PRE-HEARING STAFF ANALYSIS

Rezoning Petition No. 2008-068

Location: Approximately 11.05 acres located on the northeast corner of Eastfield Road and Highland Creek Parkway

Request: R-9(PUD), single-family residential, Planned Unit Development to NS, neighborhood services

PUBLIC STREET CROSS SECTION C-C' SCALE: NTS

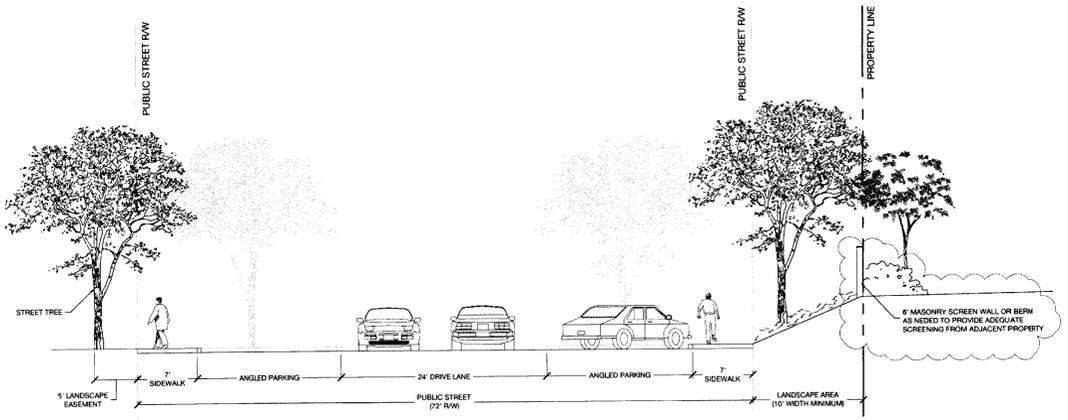
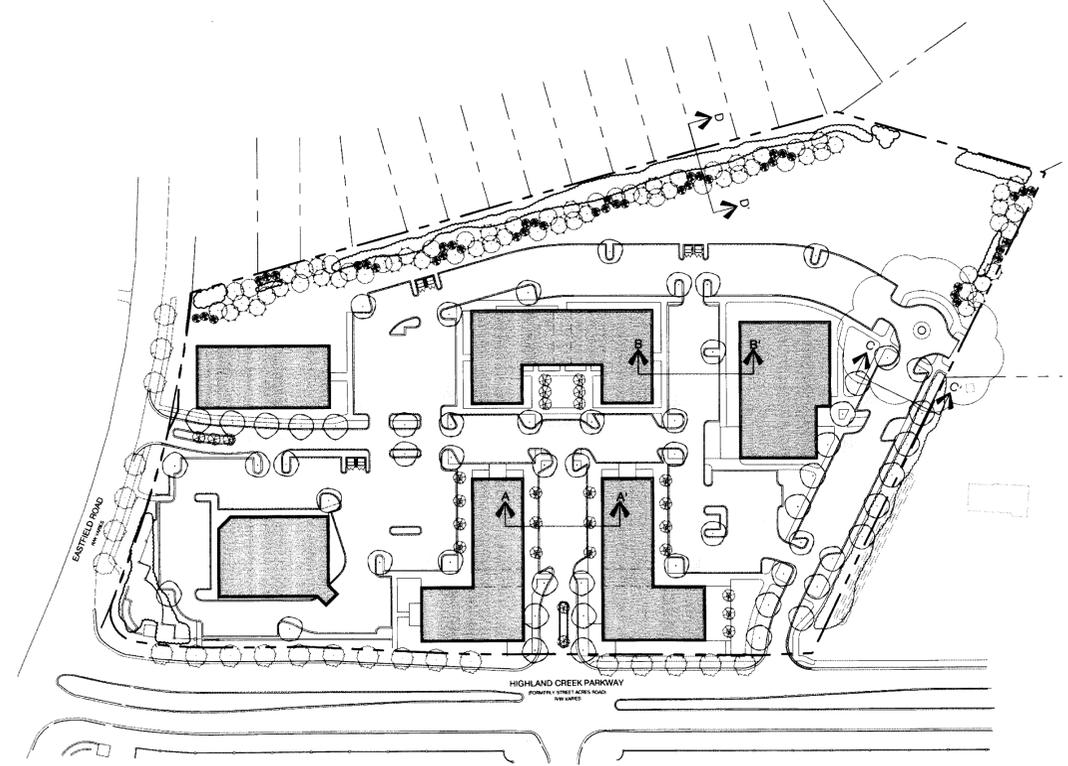
- Deletion of proposed driveway to Eastfield Road.
- Widening of Eastfield Road and the design of the required southbound Eastfield Road left-turn lane.
- Provision of minimum eight-foot planting strips and six-foot sidewalks along Highland Creek Parkway.
- The location and construction of the proposed public street and location of parking on the proposed public street.

RZ-1

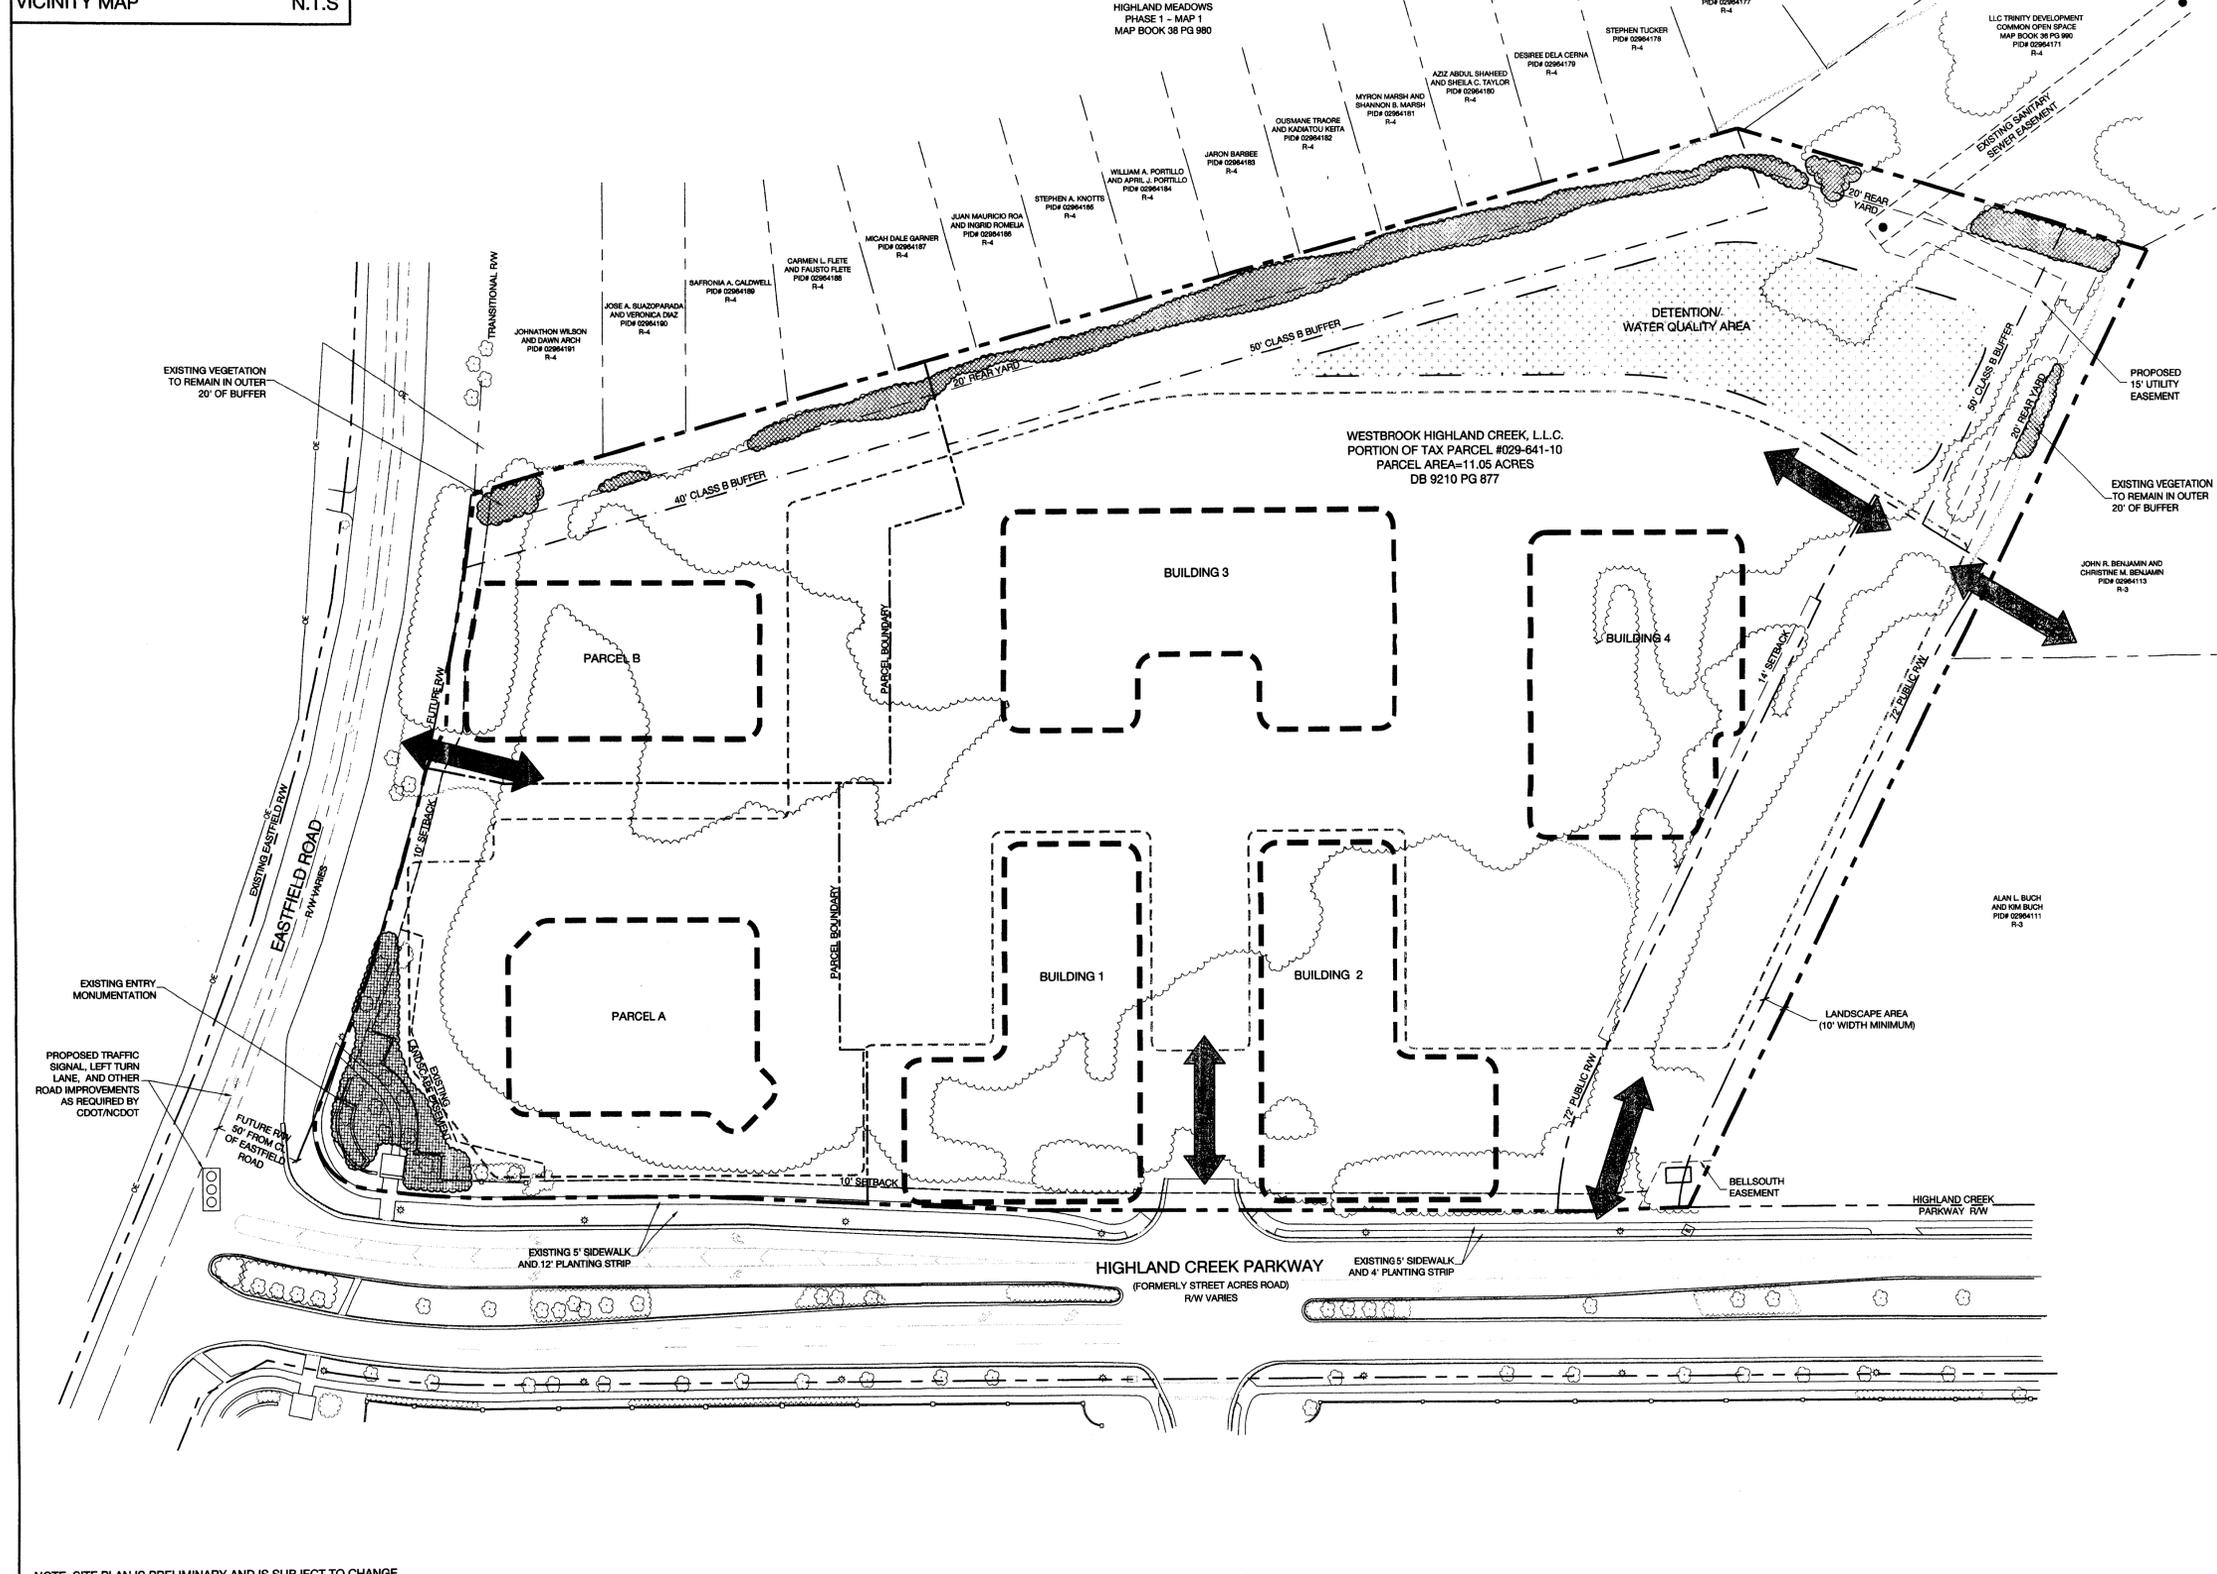
- Petitioner should add information under *Development Summary* regarding parking calculations and proposed number of parking spaces.
- Petitioner should add information under *Development Summary* regarding amount of tree save area.
- Petitioner should add under *Development Summary* maximum building height for structures on site.
- The petitioner proposes to not provide a six-foot sidewalk and eight-foot planting strip where a five-foot sidewalk and 12-foot planting strip exist along a portion of Highland Creek Parkway. Planning staff concurs with CDOT in that a minimum six-foot sidewalk should be provided while the existing 12-foot planting strip may remain.

- The site plan shows building footprints with potential building breaks. Petitioner should clarify the nature of these potential building breaks, as the intent should be to encourage a pedestrian-scale, pedestrian-friendly environment while reducing the number of freestanding structures on the site.
- Petitioner should provide elevations of the buildings.
